2023 Financial Assurance Estimate Form (with pre-plat construction)

PROJECT INFORMATION		
Space Village Filing No. 4	4/17/2023	MS227
Project Name	Date	PCD File No.

SPACE VILLAGE FILING NO. 4  
A PORTION OF THE NW 1/4 OF SEC. 17, T14S,  
R65W, OF THE 6th P.M., EL PASO COUNTY, COLORADO  
GRADING & EROSION CONTROL PLAN

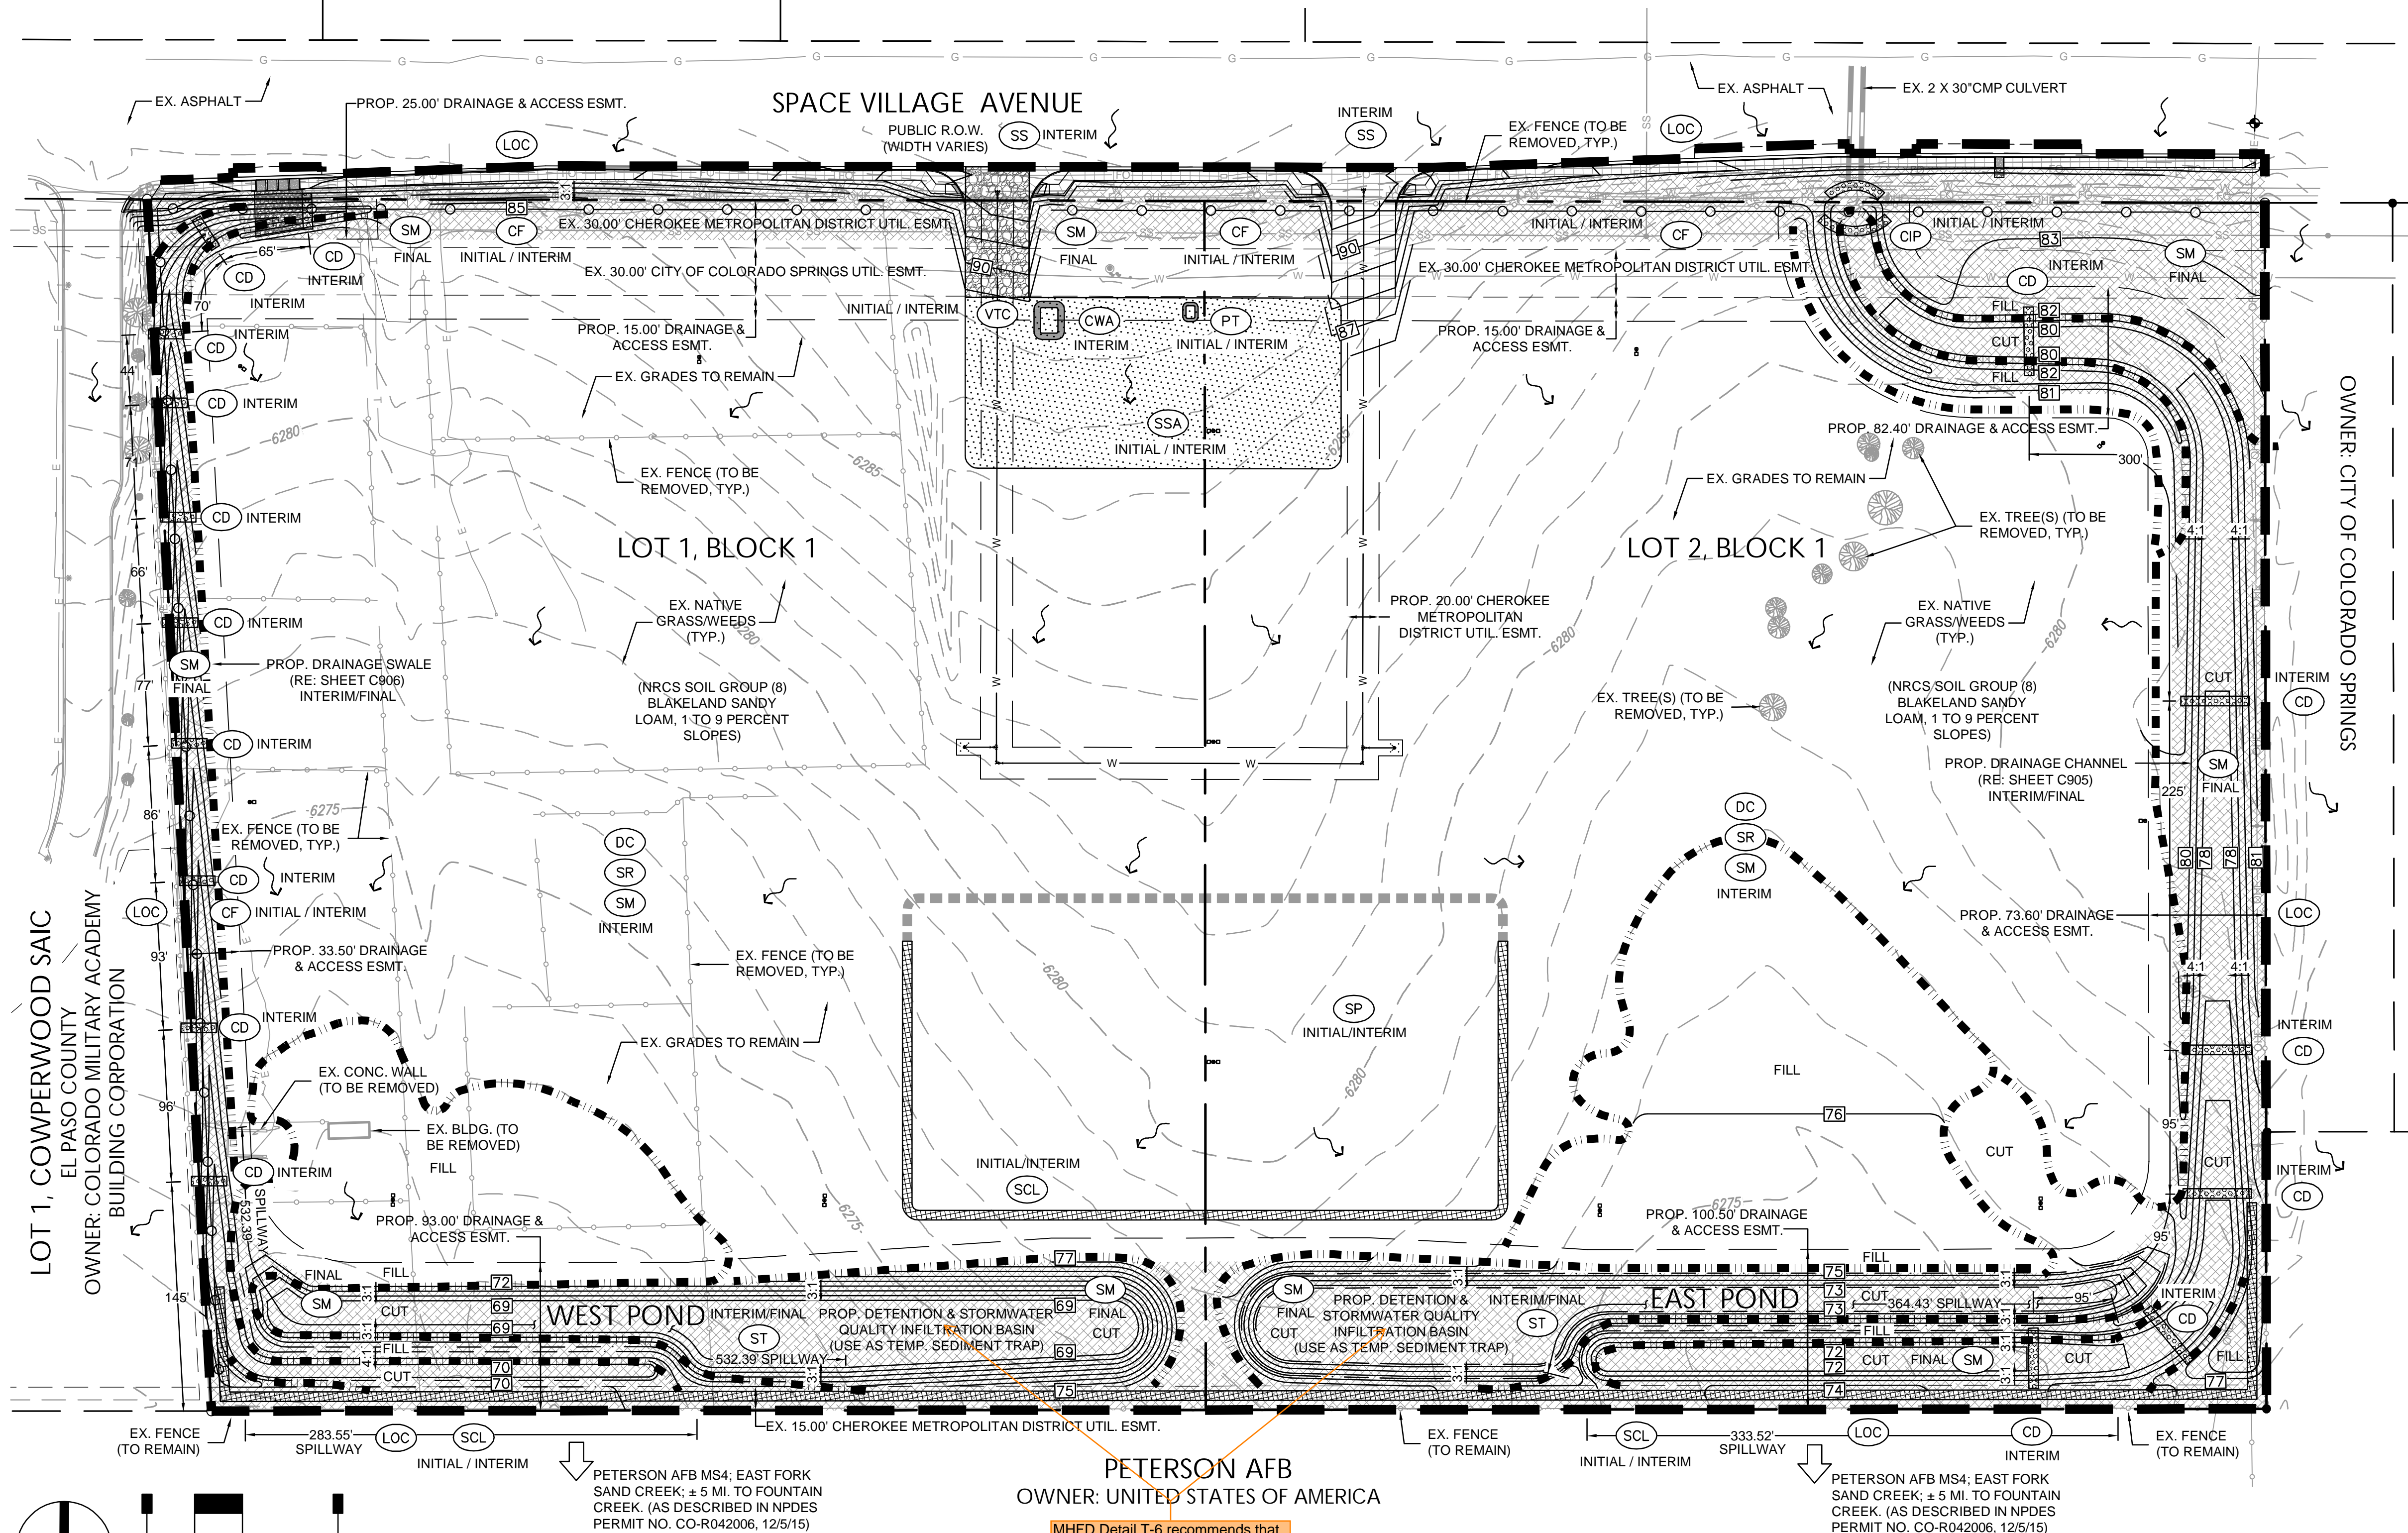
The plans show seeding and mulching as a "final" BMP. So these quantities be moved up to rows for "permanent" seeding and mulching.
